Luminato green roof specifications

To meet the green roof requirement for a height bonus at least half of the lot needs to be pervious and at least half of the combined roof area needs to be green roof. This means that the site pervious surface and the green roof need to add up to at least 5,135 sf. I need a clear diagram that indicates what the combined roof area is as

DIAGRAMS NEEDED

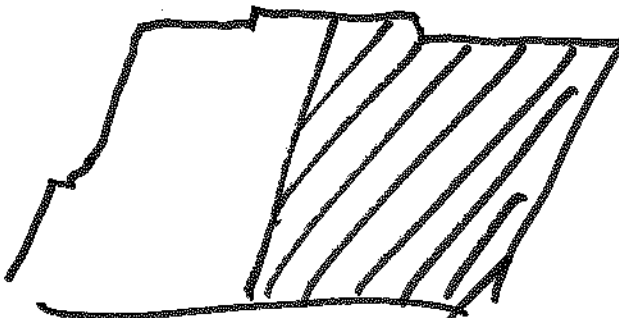
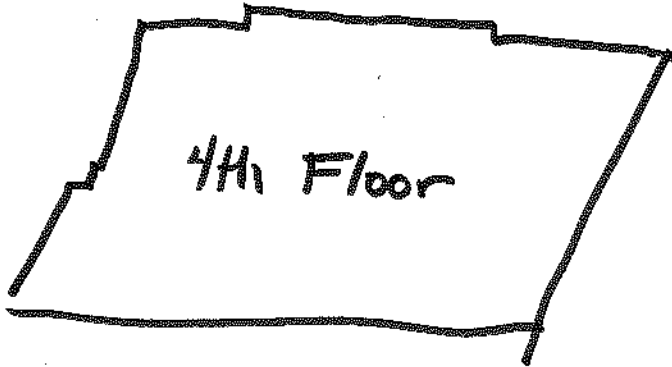
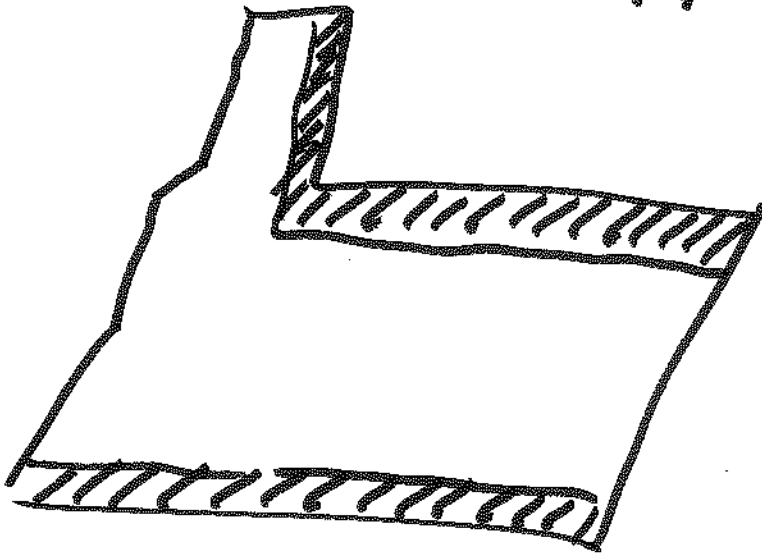
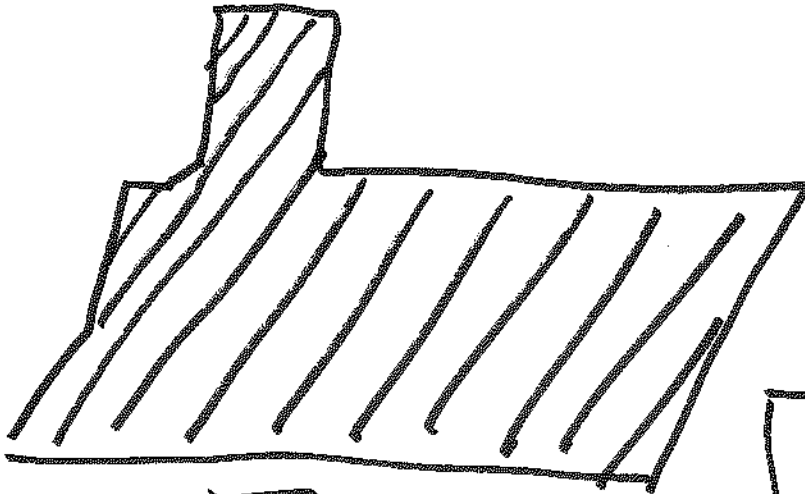
However, in the meantime, I need a diagram to the effect of the attached document that clearly lays out that the requirement is met.

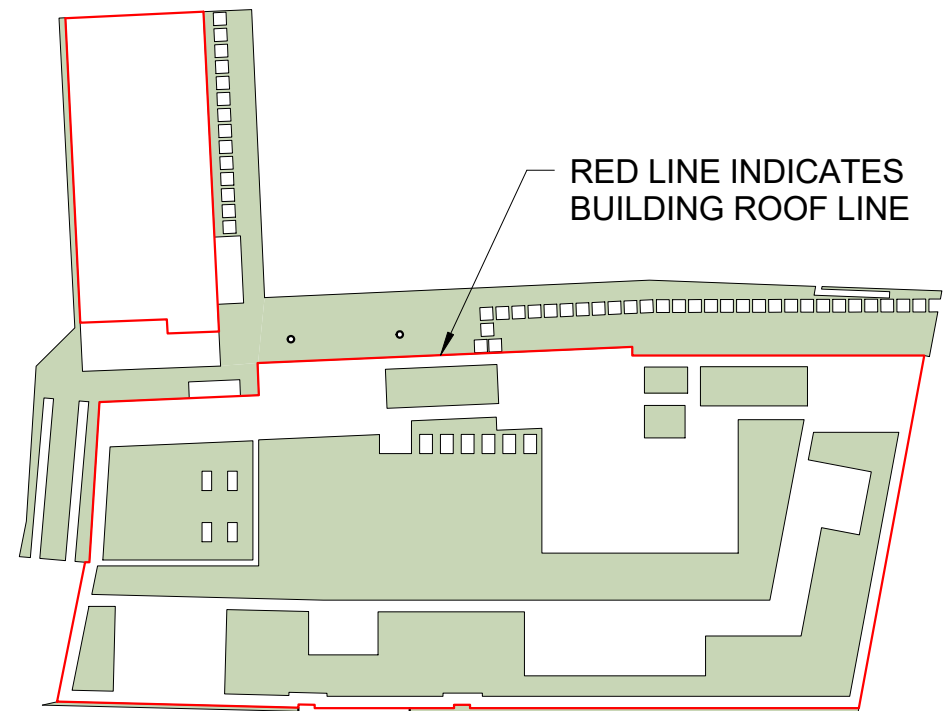
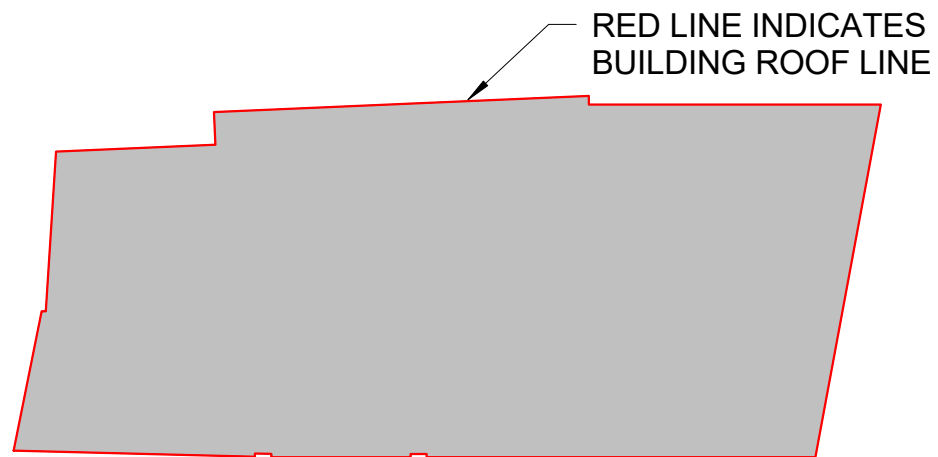
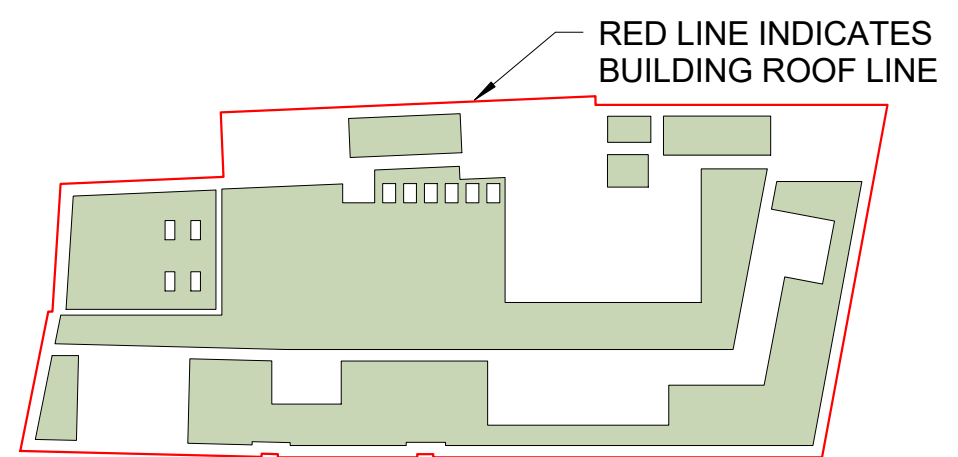
well as the pervious areas of the site and their total sf. The combined roof area will be the sf of the 4th floor plan including all roof decks, circulation towers, etc.
